Our Ref: P/72/17/PL
Your Ref:

Town & Country Planning Act 1990 (as amended)
Town and Country Planning (Development Management Procedure) (England) Order 2015
Application for Planning Permission

Development Replacement of existing windows with white UPVc windows
Location The Lamb Inn 144 Pagham Road Pagham

DRAWING No
234/01

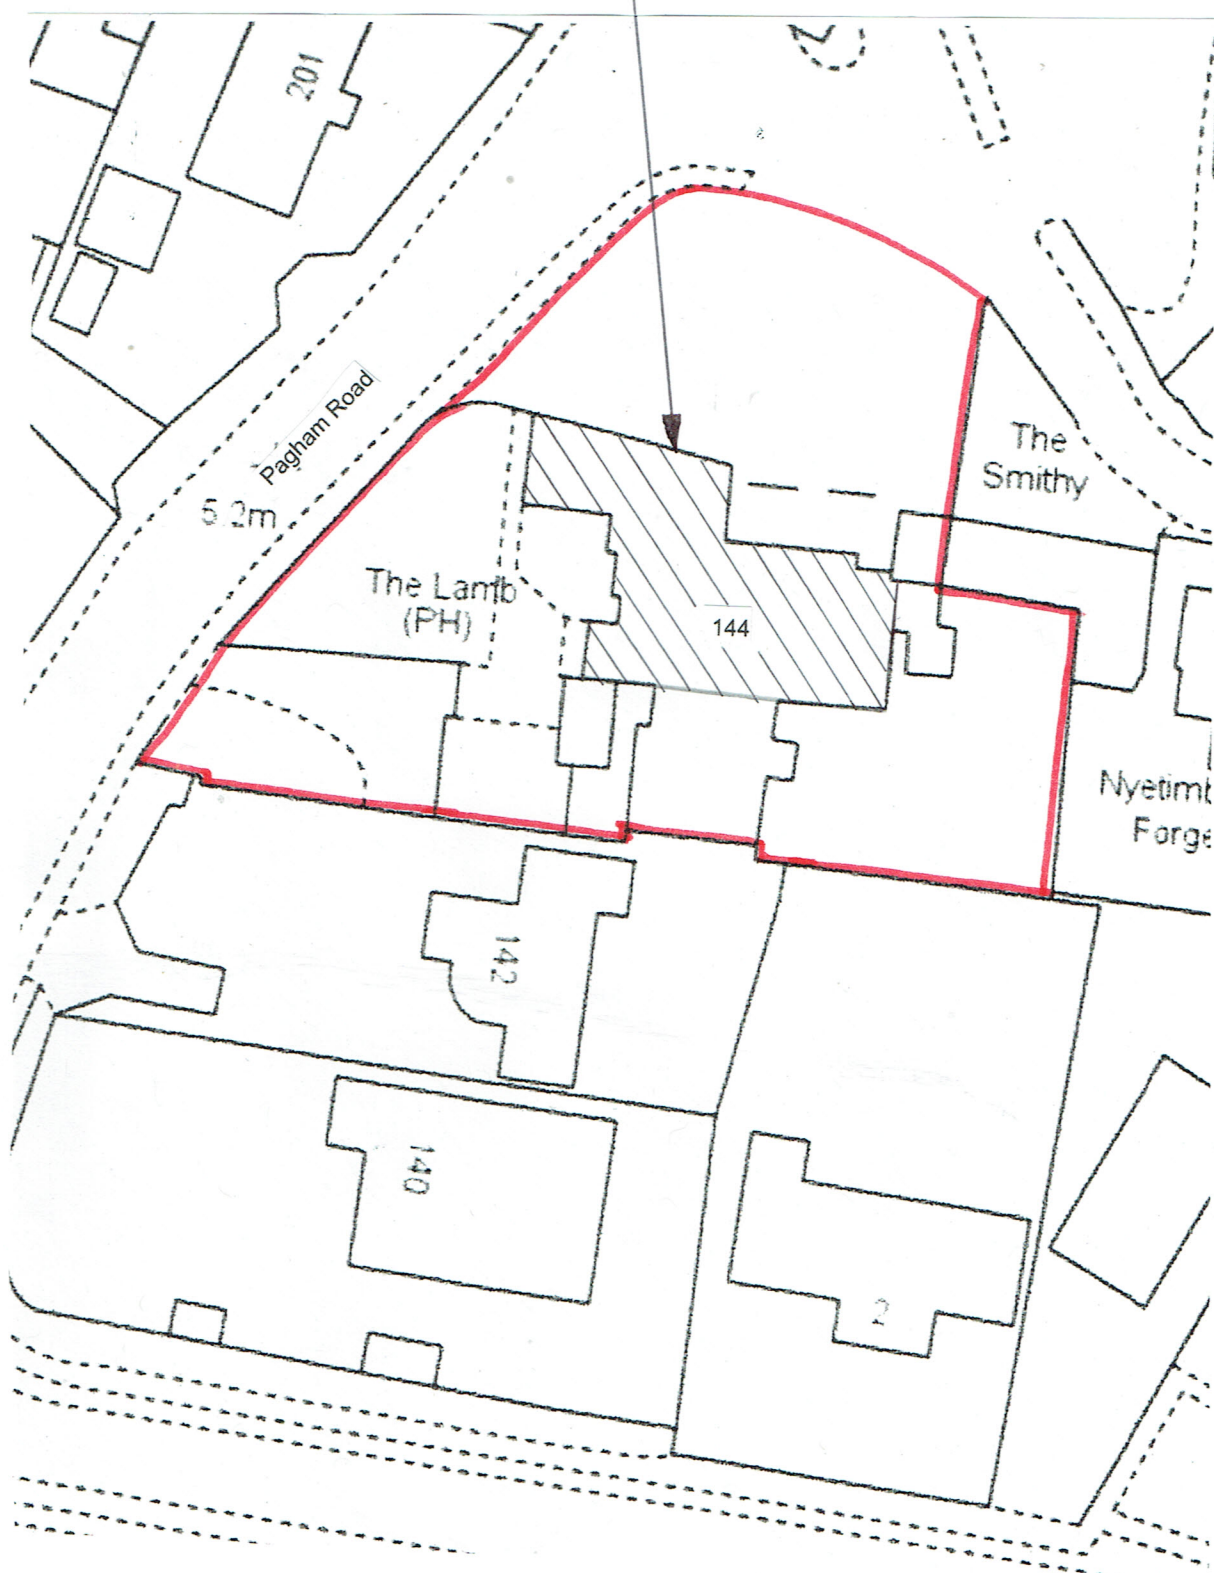
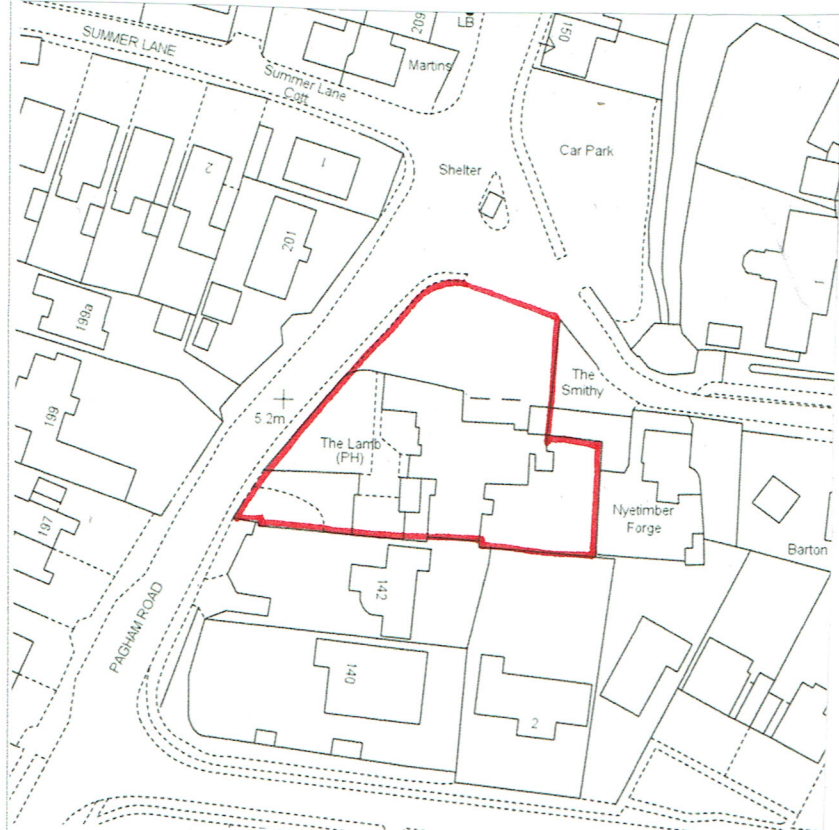
Block Plan - Revised

Please submit 1 electronic or 3 paper copies of a revised block/site plan at a scale of 1:500 or 1:200 with the windows being replaced clearly highlighted. Further details of what must be included on the plan can be found in the National Validation Requirements.
